City of Portland, Maine - Building or Use Permit Application
 389 Congress Street, 04101 Tel: (207) 874-8703, Fax: (207) 874-8716

Permit No: 07-1399	Issue Date:	CBL: 434 C002001
------------------------------	--------------------	----------------------------

Location of Construction: 281 VERANDA ST	Owner Name: ATLANTIC PROPERTIES LLC	Owner Address: 970 BAXTER BLVD	Phone:
Business Name:	Contractor Name: Donatello Builders Inc./Larry	Contractor Address: P.O. Box 684 Portland	Phone 2072327220
Lessee/Buyer's Name	Phone:	Permit Type: Additions - Commercial	Zone:

Past Use: Commercial - Office	Proposed Use: Commercial - Office - 62 Sq Ft addition & interior renovations to existing space	Permit Fee: \$490.00	Cost of Work: \$47,000.00	CEO District: 4
Proposed Project Description: 62 Sq Ft addition & interior renovations to existing space		FIRE DEPT: <input type="checkbox"/> Approved <input type="checkbox"/> Denied	INSPECTION: Use Group: Type	
		Signature: _____		Signature: _____
PEDESTRIAN ACTIVITIES DISTRICT (P.A.D.)				
Action <input type="checkbox"/> Approved <input type="checkbox"/> Approved w/Condition <input type="checkbox"/> Denied				
Signature: _____ Date: _____

**11 SECTION AT NEW ADDITION**  
SCALE: 1/4" = 1'-0"

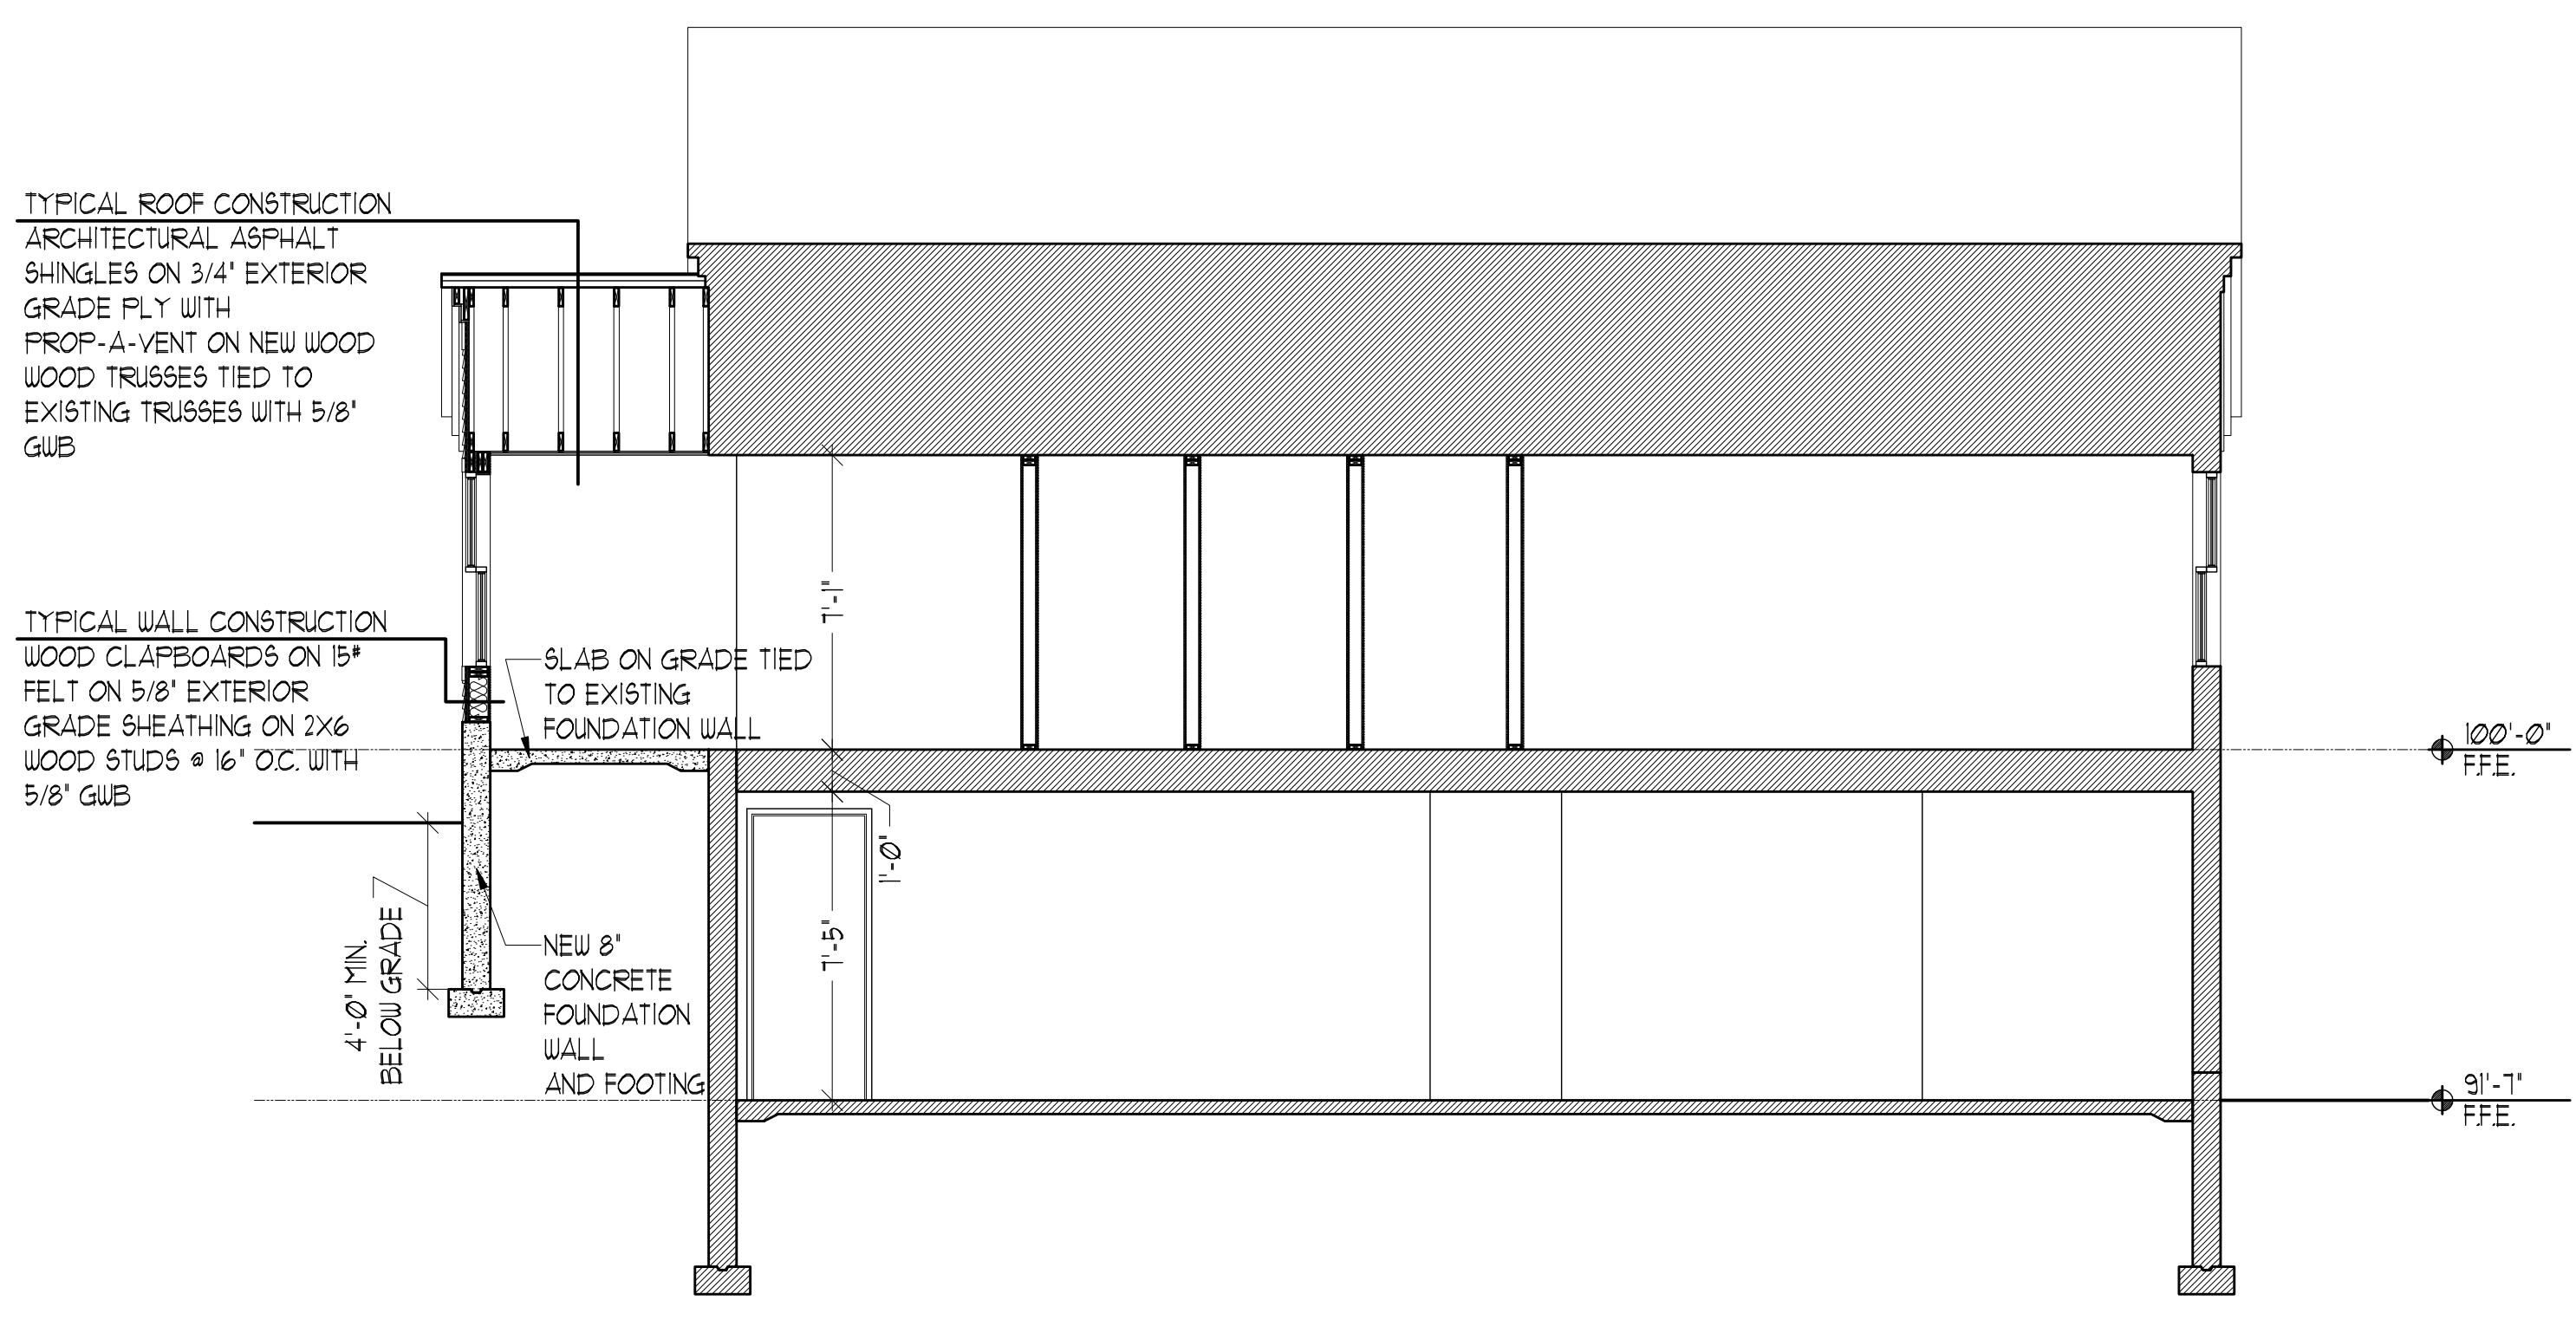
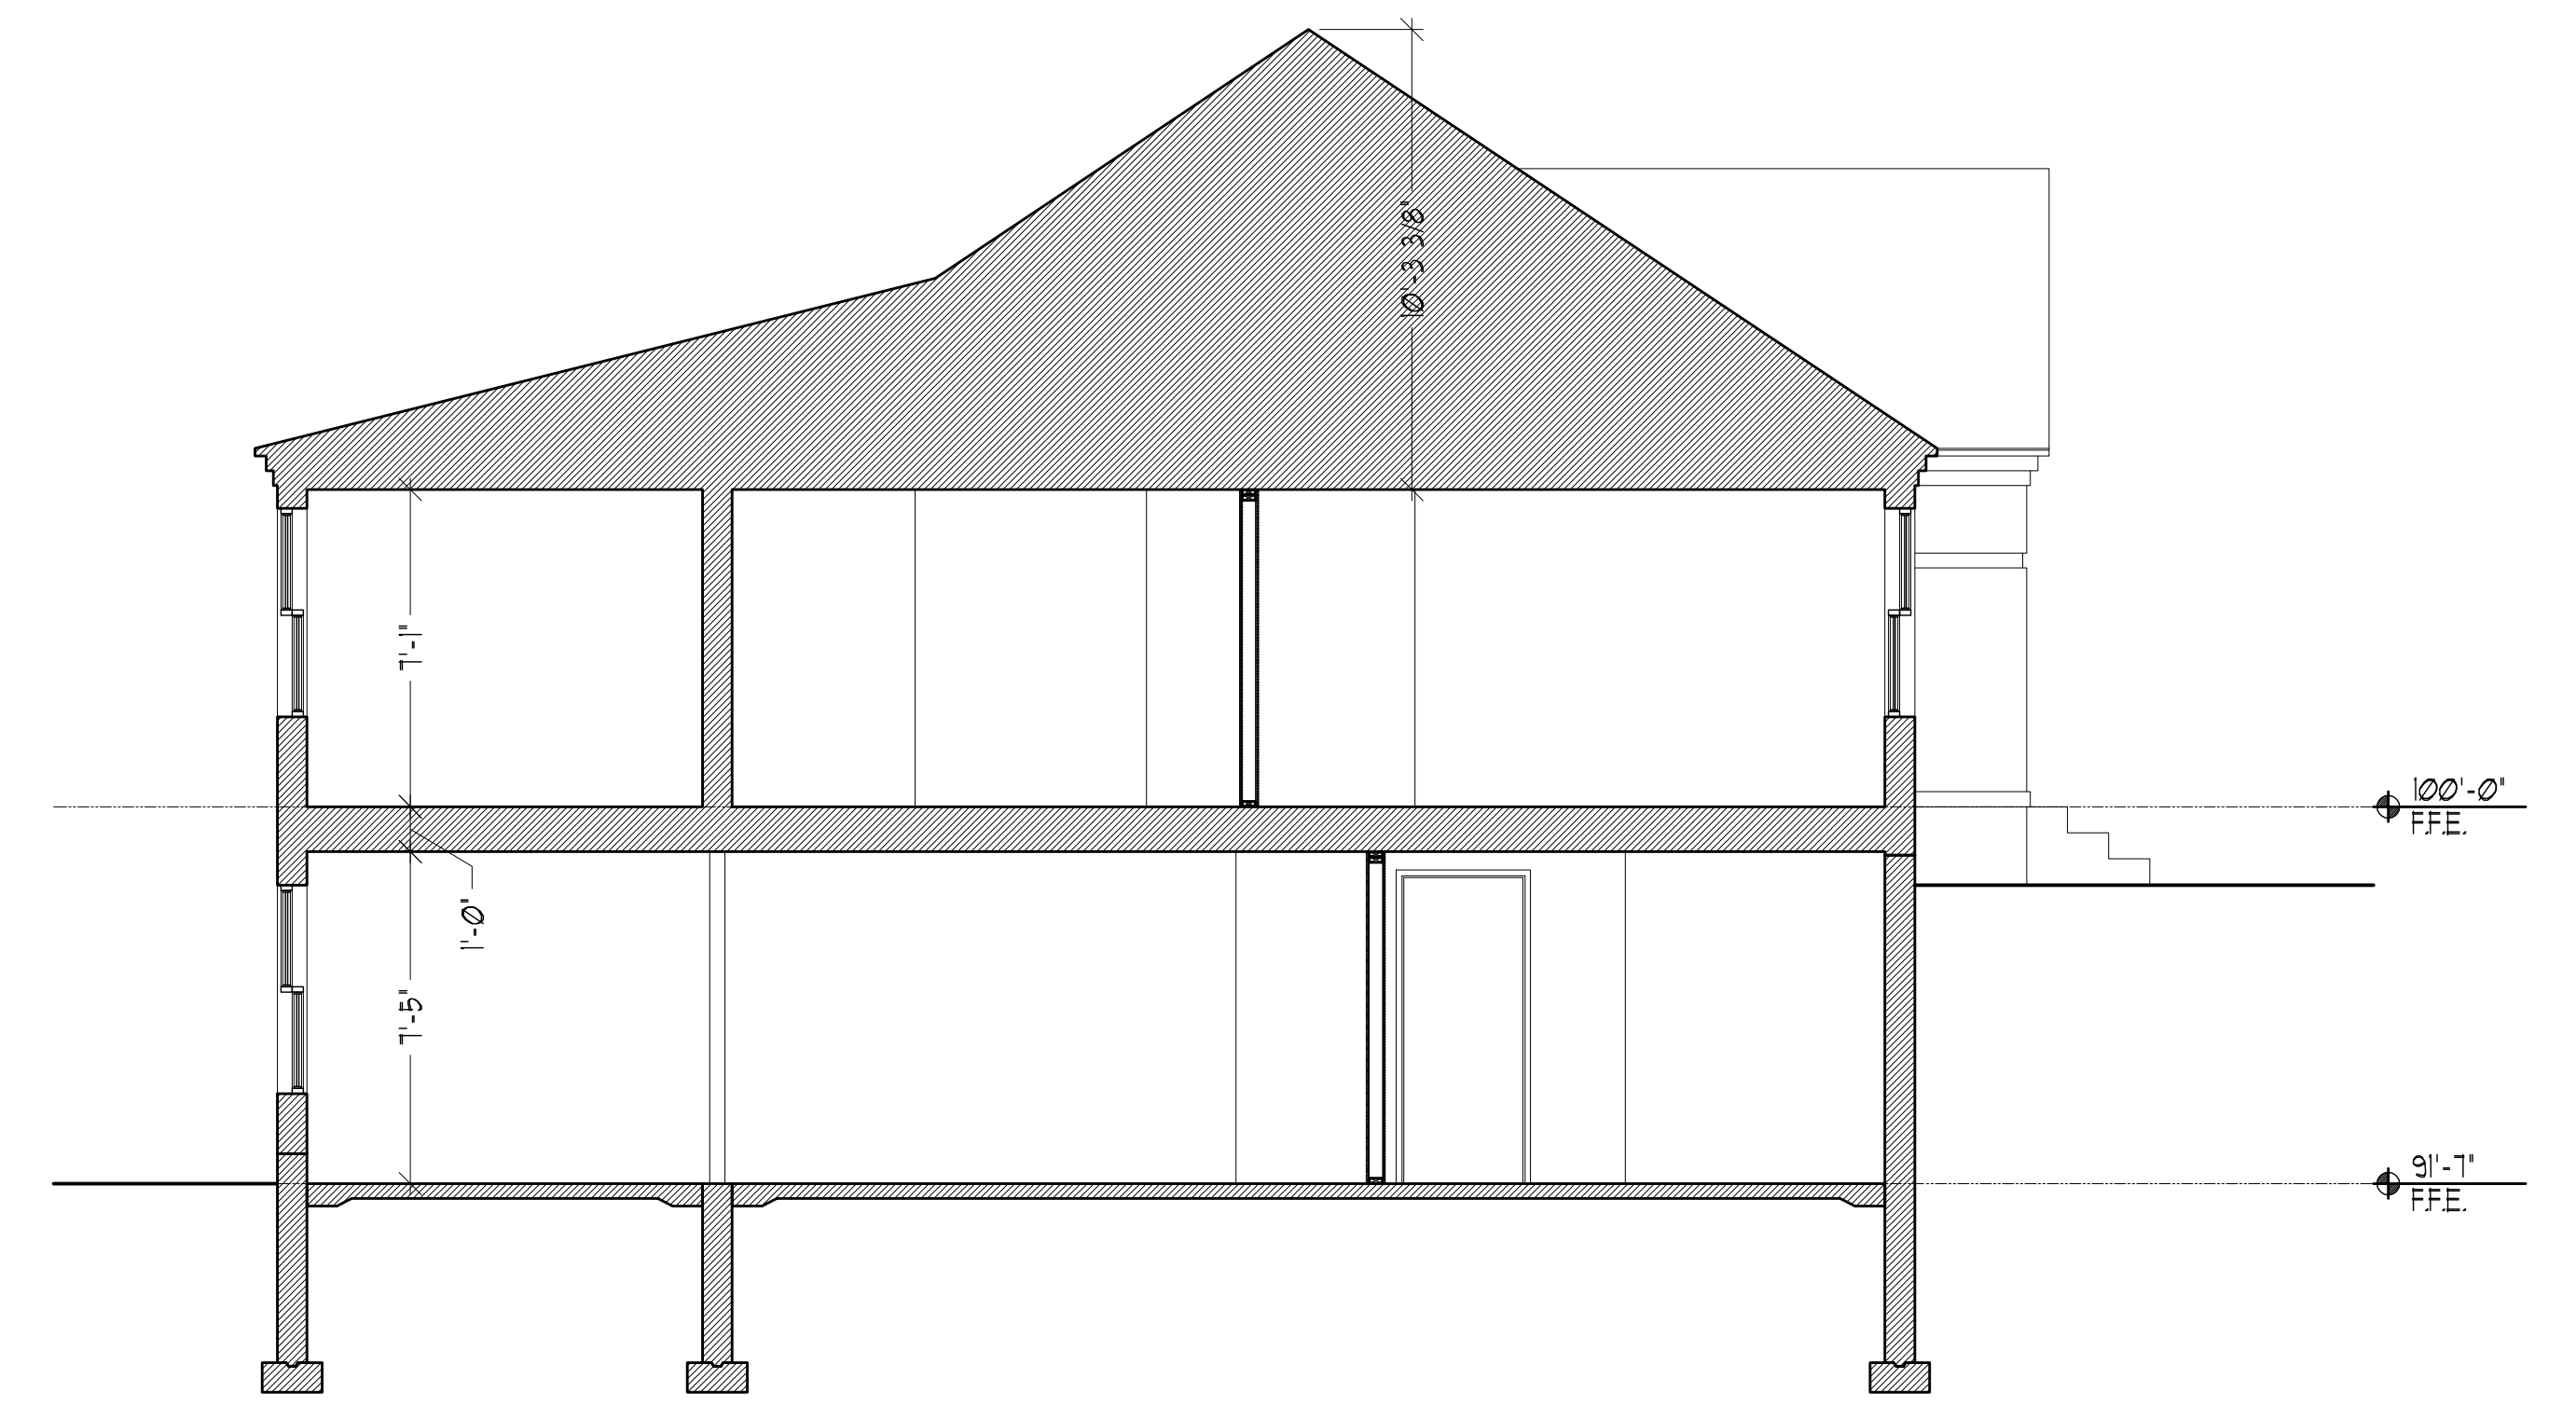
Note: need framing details addition - no info submitted on addition **Ok to Issue:**

1/8/2008-tmm: need framing details addition - no info submitted on addition - called designer and requested info /tmm
